**CBP 9-2 CLAREMONT BUSINESS PARK 1405 SELIX GROVE COLORADO SPRINGS, CO**

COUNTY FILE NO. PPR-19-026

# Landscape\_v2-redline.pdf Markup Summary

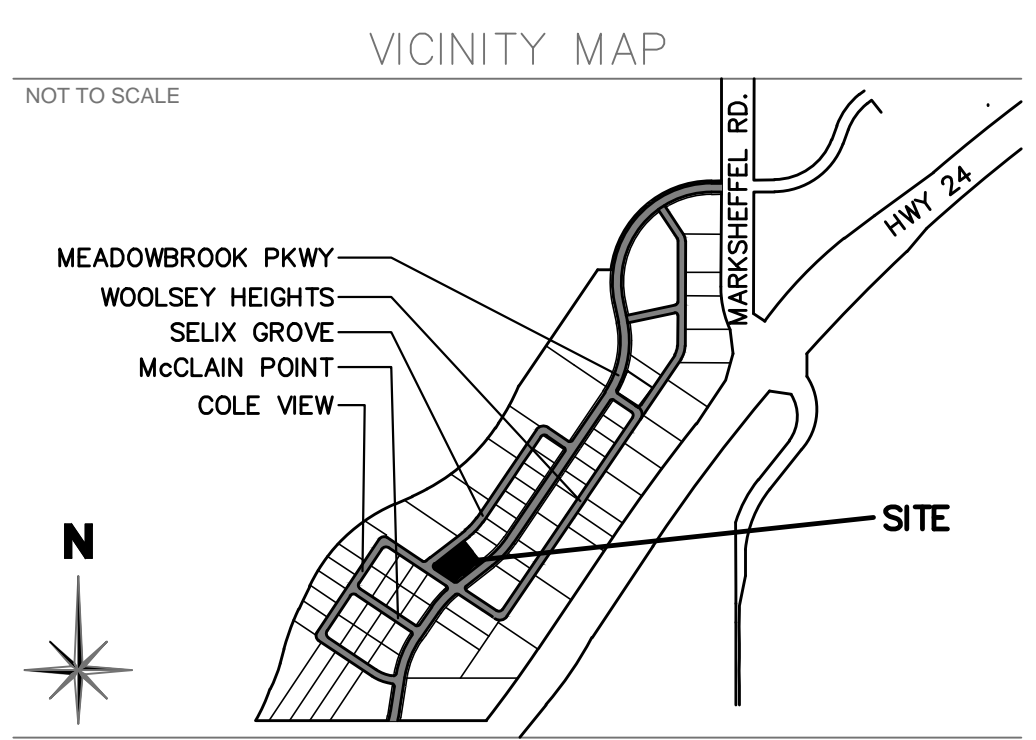
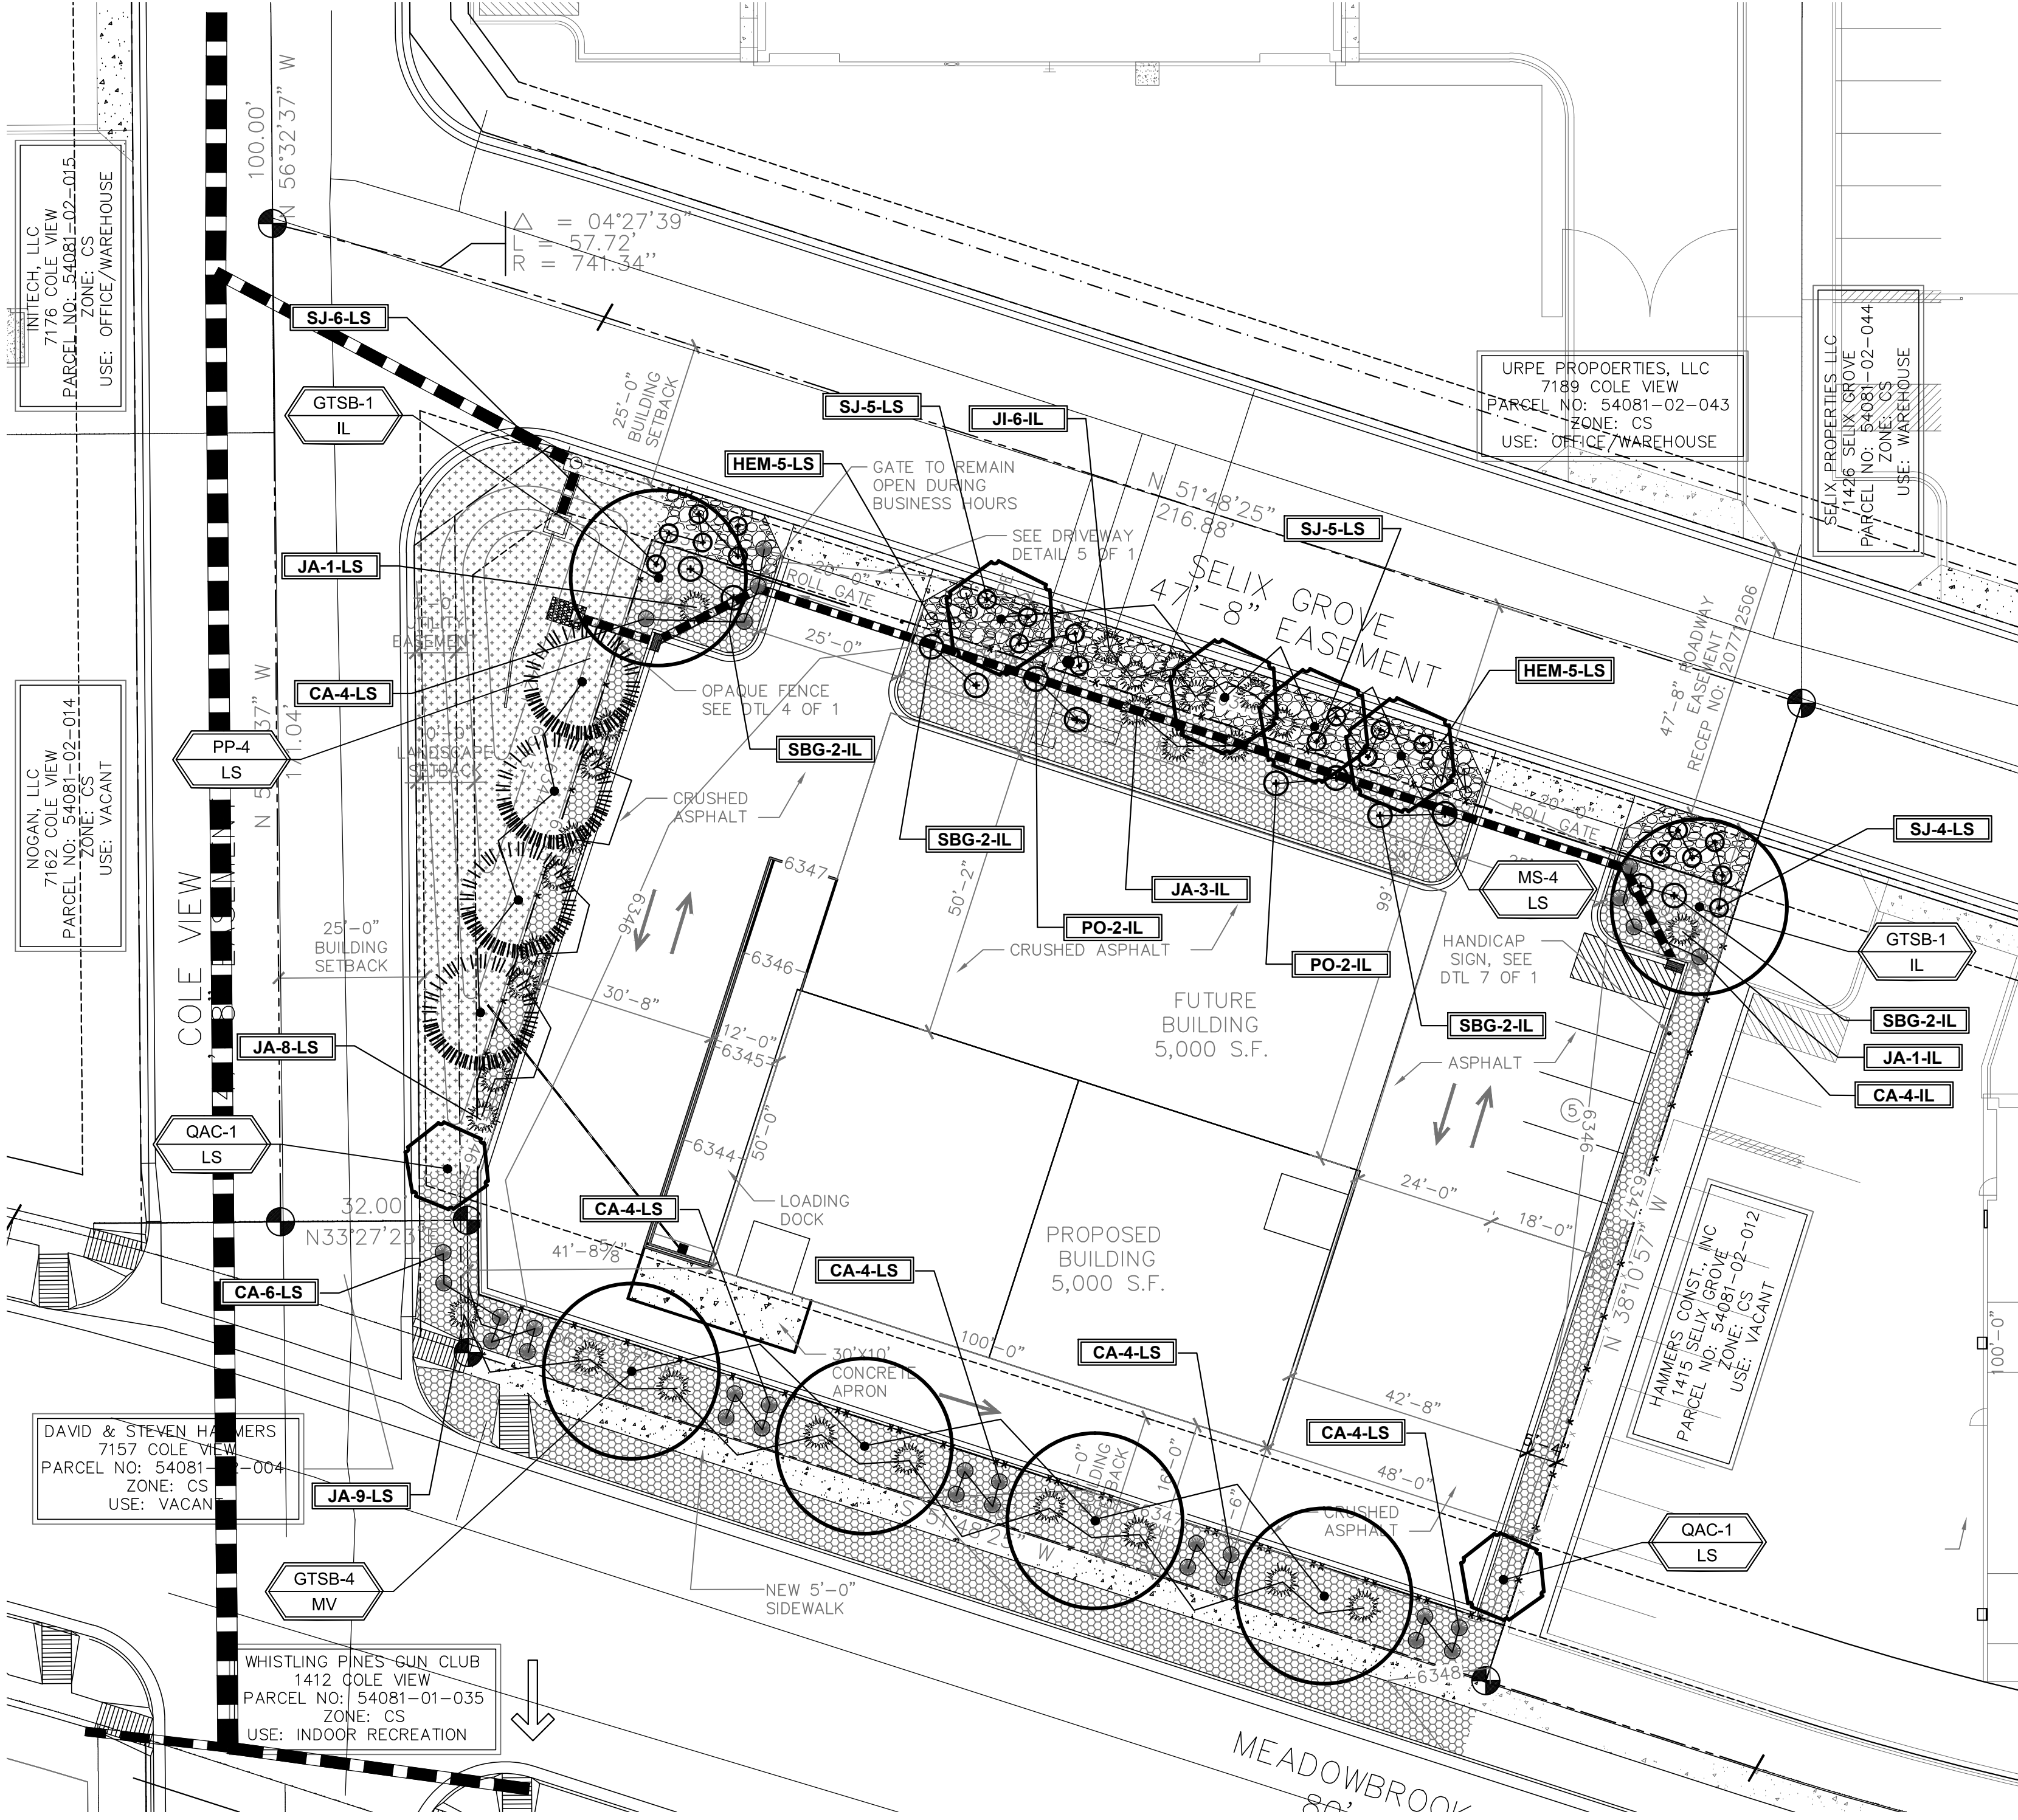
This is deficient.
